A46 Newark Bypass

Statement of Common Ground with Think Again A46 Winthorpe Action Group

**Statement Of Common Ground with
Think Again A46 Winthorpe Action Group - TA**

Version	Date	Status of Version
Rev 0	October 2024	Deadline 1
Rev 1	November 2024	Deadline 2

**Figure 2.4 Locations of Temporary Works Areas Required During
Construction**

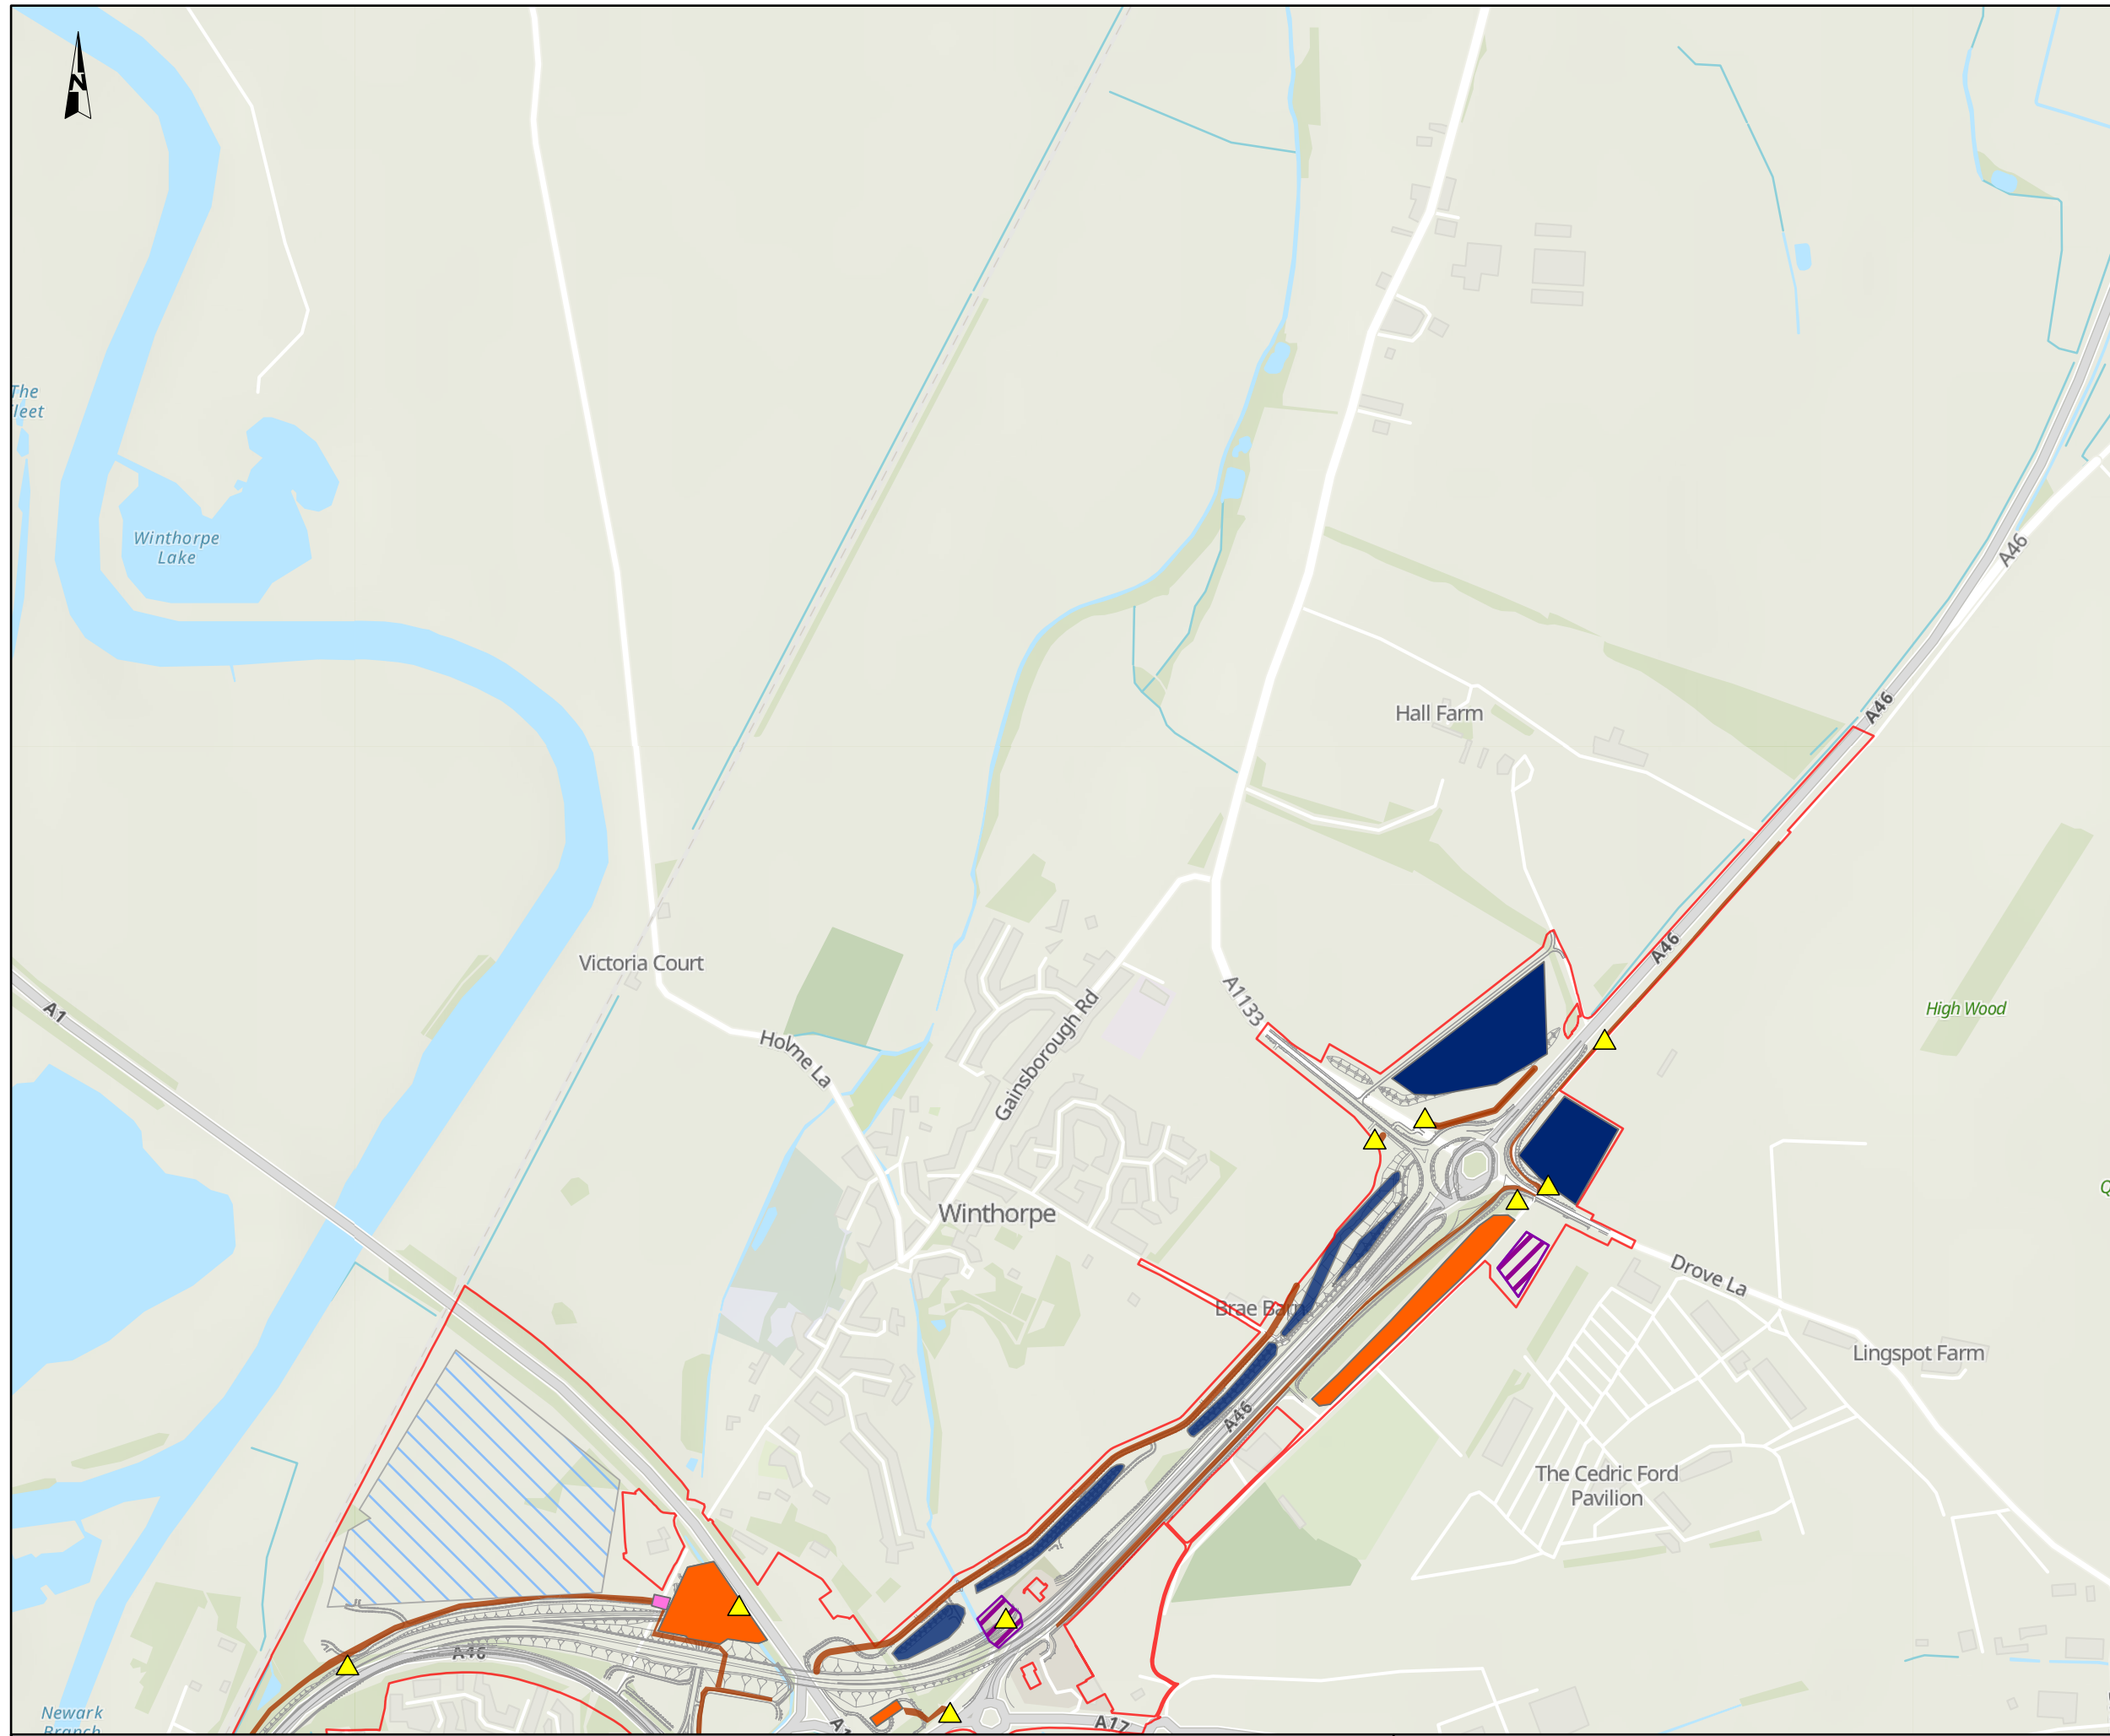
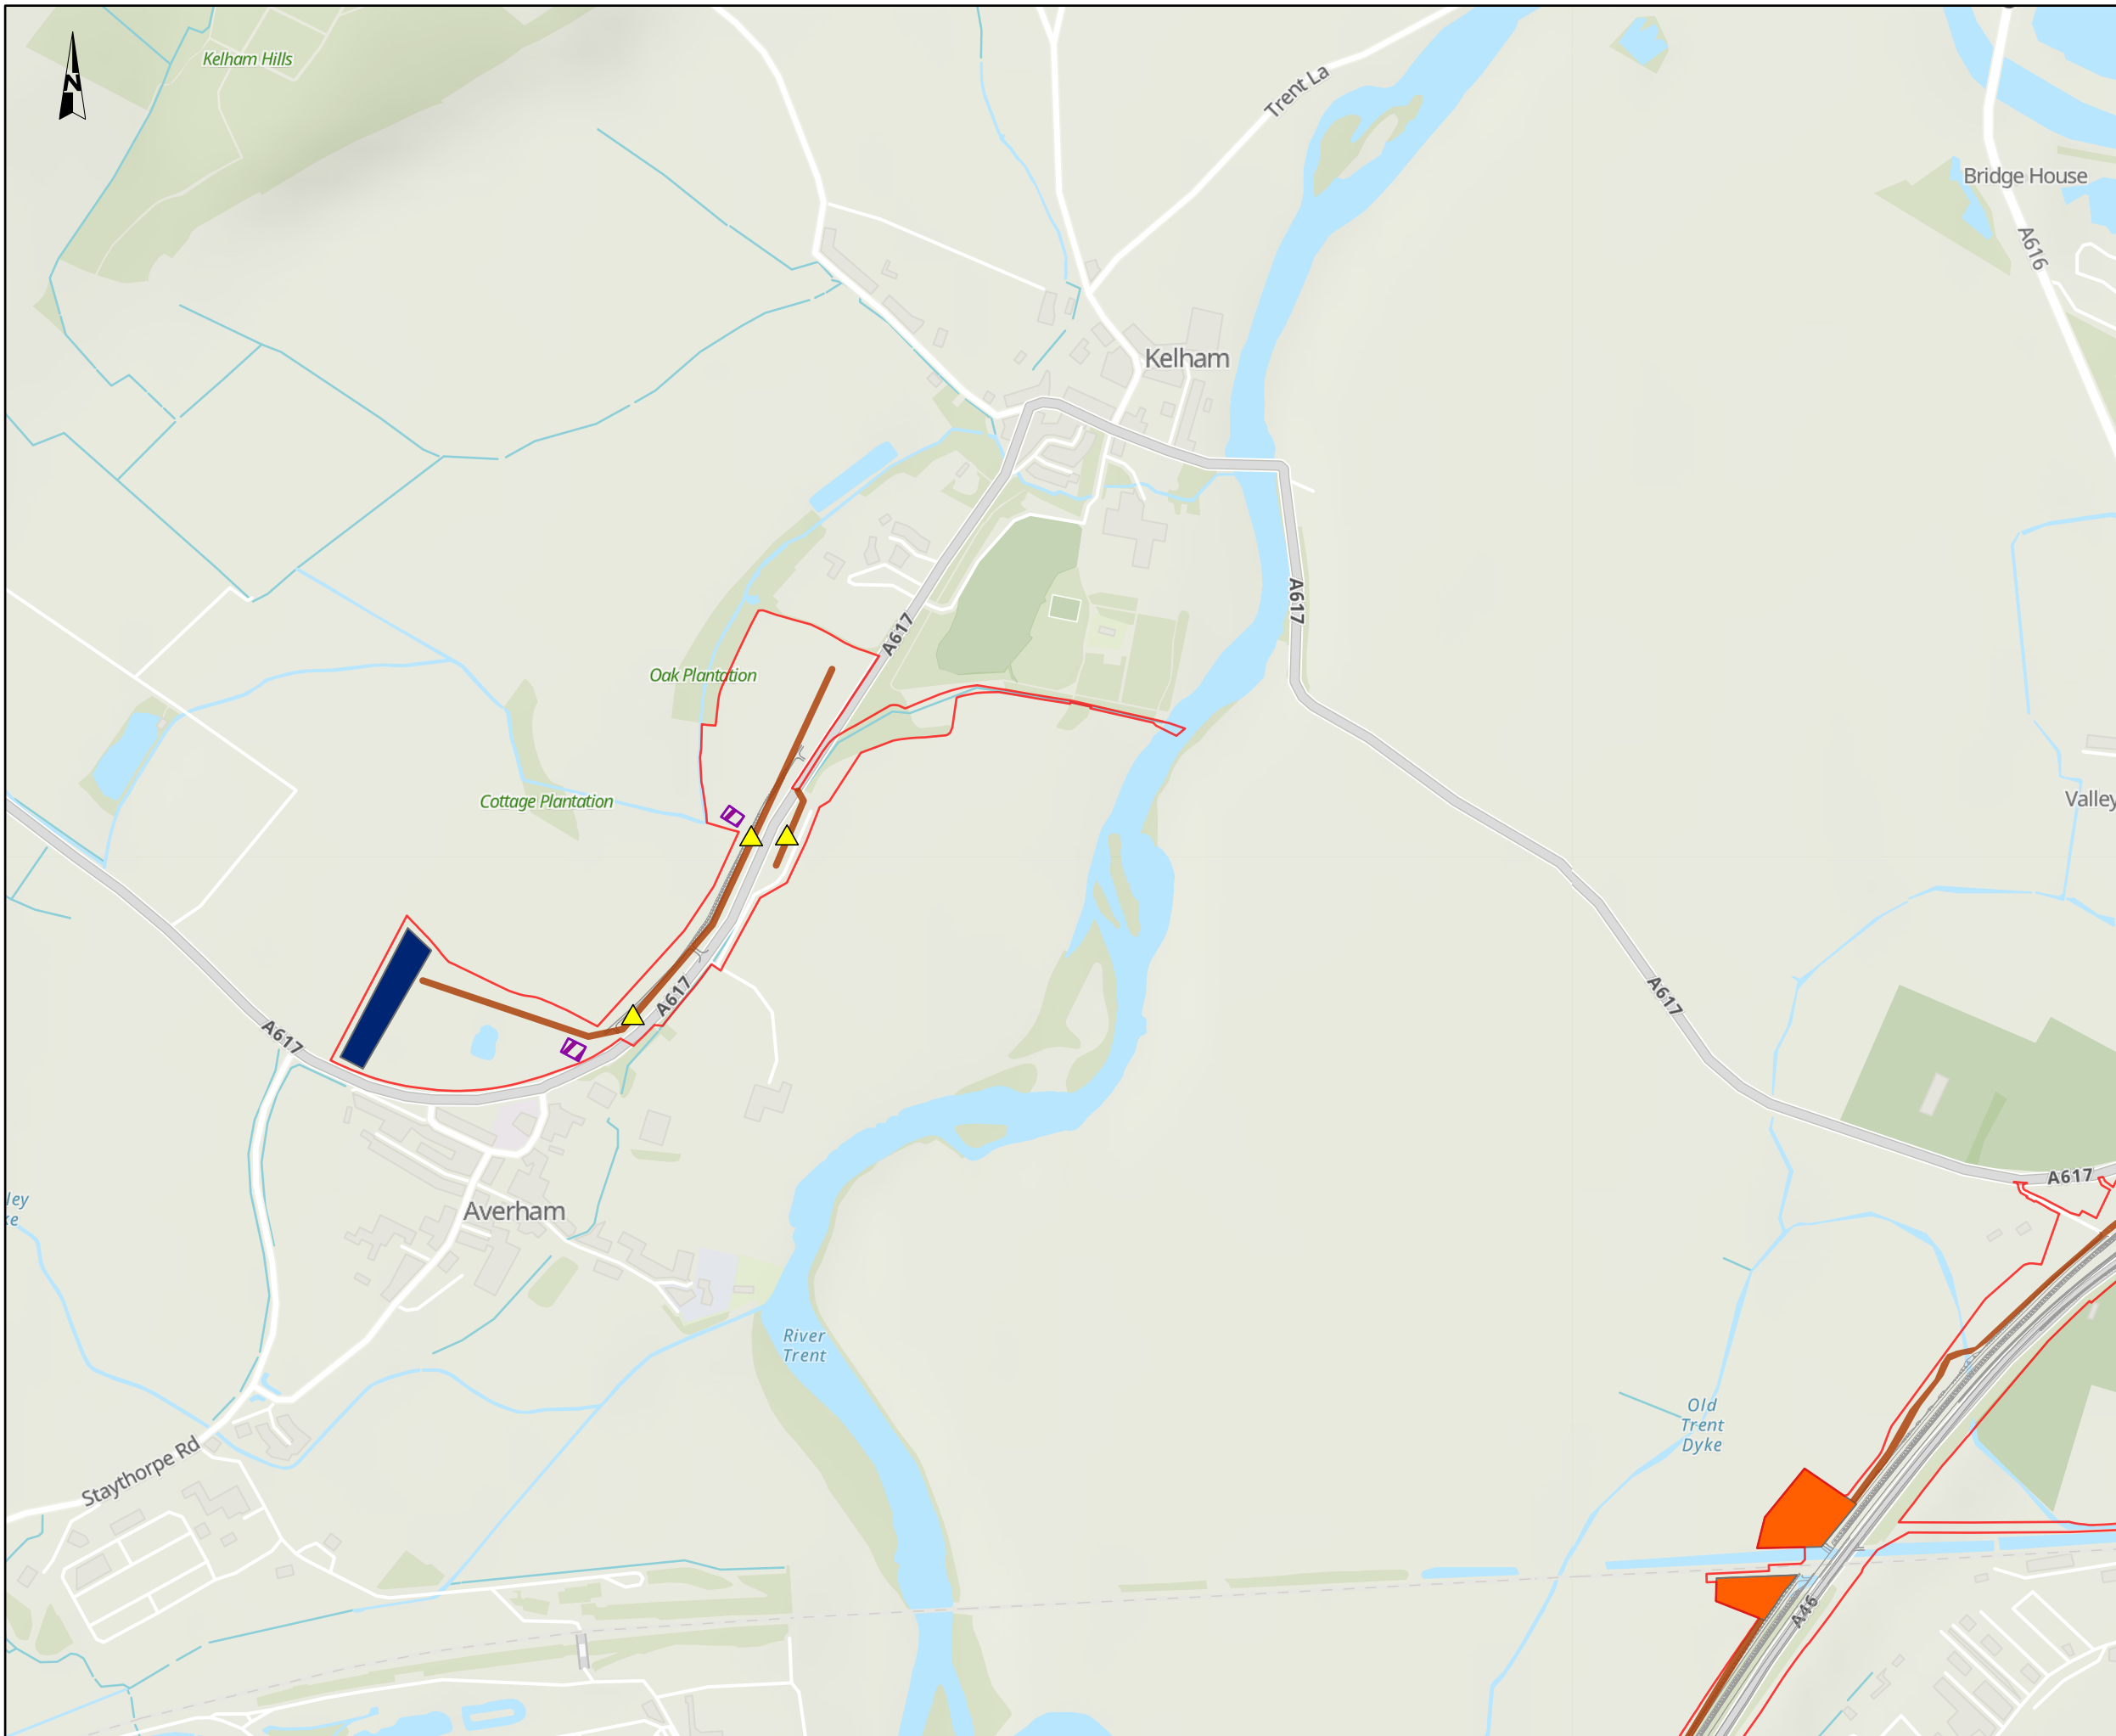
20.	Construction Compounds	<p>Figure 2.4 Locations of Temporary Works Areas Required During Construction of the Environmental Statement Figures [AS-027]</p> <p>Table 2-6 in Chapter 2 The Scheme of the Environmental Statement [APP-046]</p>	What construction compounds and works access facilities will be located in the Winthorpe area?	The location of the construction compounds and works access areas within the Winthorpe area are detailed on Figure 2.4 Locations of Temporary Works Areas Required During Construction of the Environmental Statement Figures [AS-027] and in Table 2-6 in Chapter 2 The Scheme of the Environmental Statement [APP-046].	Agreed	24/09/2024
